DOC16/446829, File No. EF13/8250

**Wallarah 2 Coal Project – Amended Development Application (SSD 4974) Notice of Exhibition**

## **Attachment A – EPA - Further Information Required**

* Values in **bold** indicate locations where predicted PM_{2.5} > PM₁₀

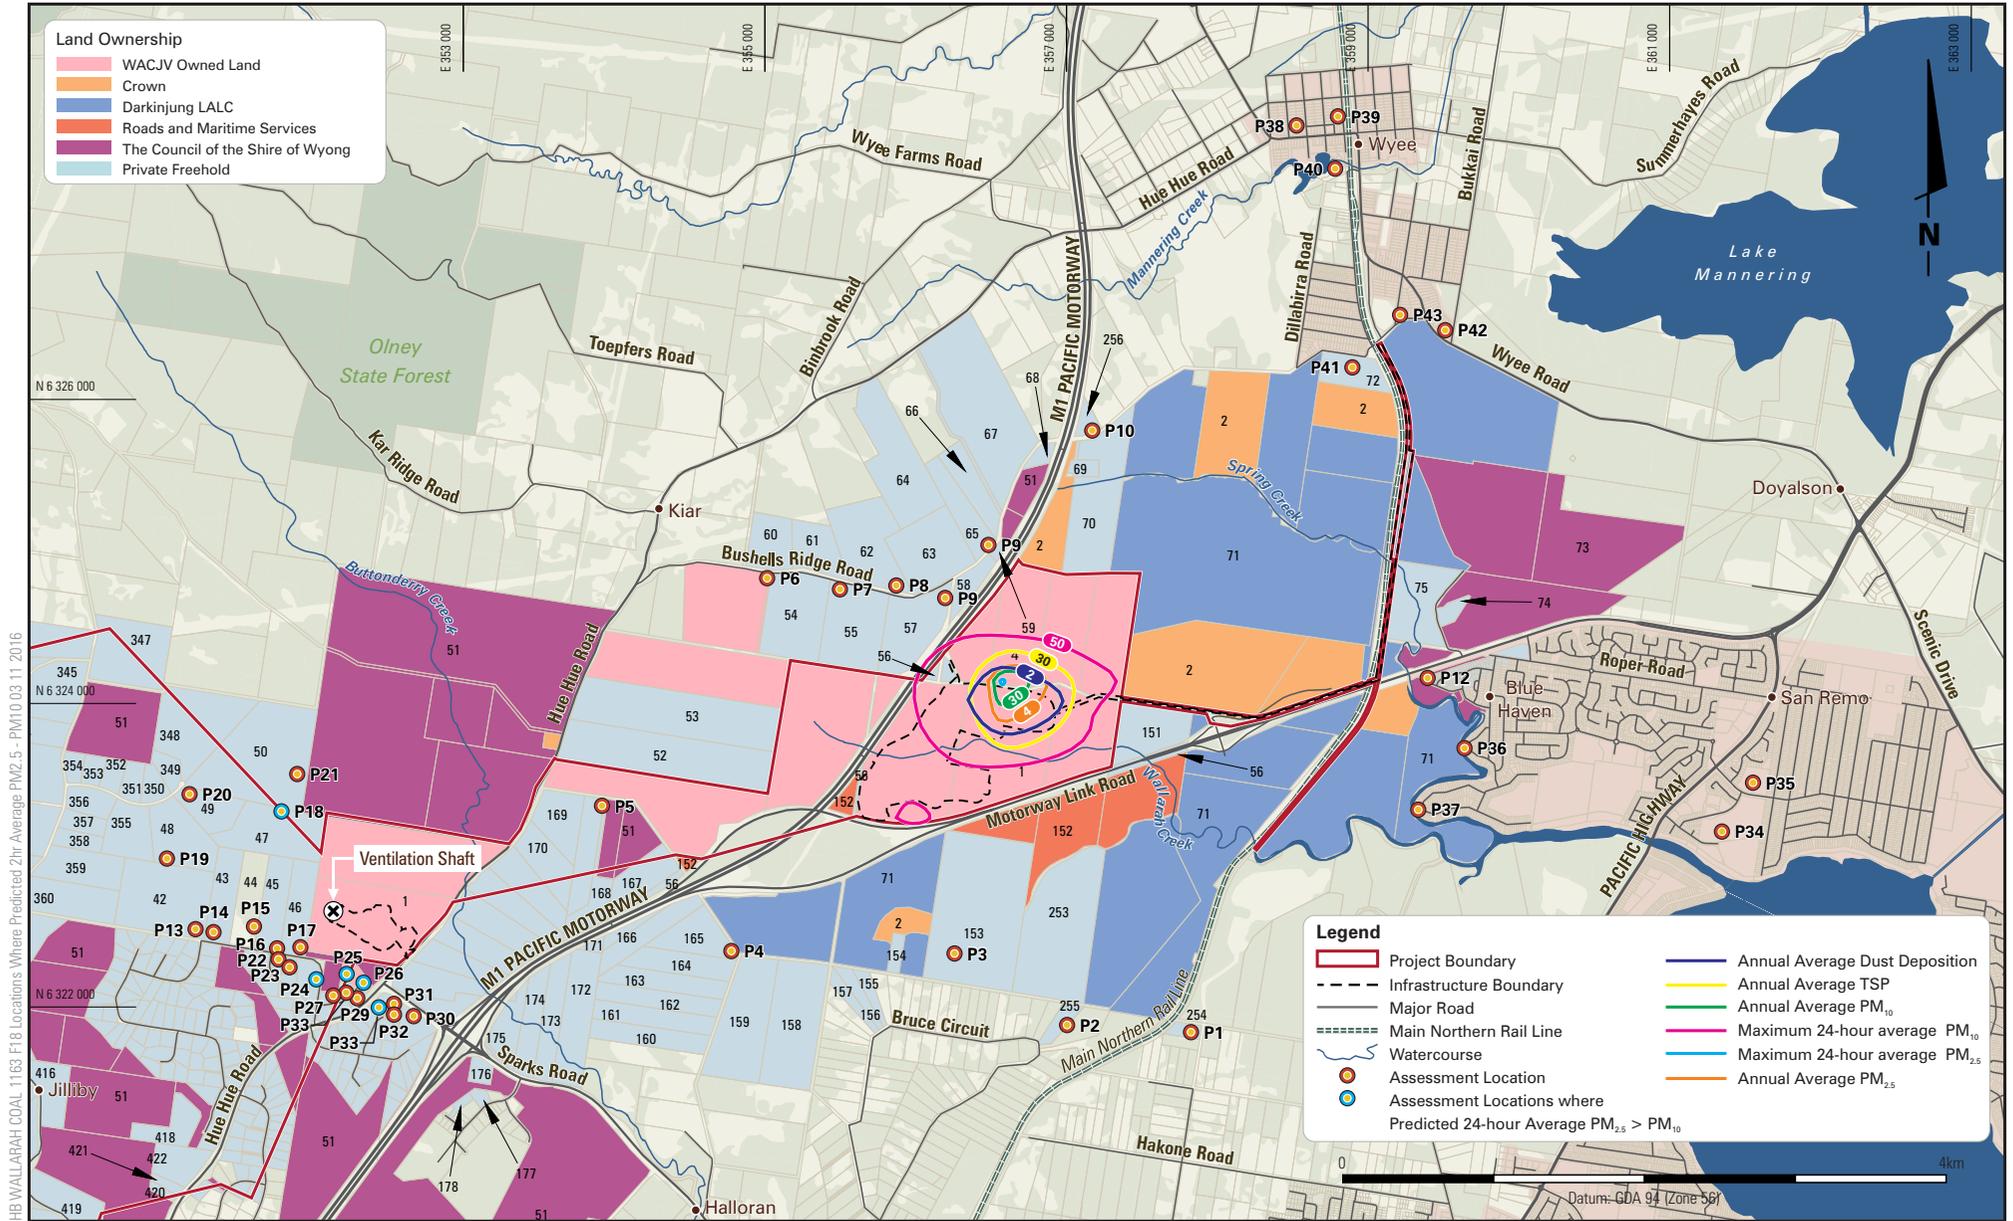
Table 7.1 of the assessment presents a summary of modelling results for PM<sub>2.5</sub>, PM<sub>10</sub> and TSP. In some instances, maximum PM<sub>2.5</sub> predictions are marginally higher than the maximum PM<sub>10</sub> predictions. As PM<sub>2.5</sub> is a sub-fraction of PM<sub>10</sub>, these results appear to be in error. The proponent should check and confirm the modelling results presented in the air assessment are correct.
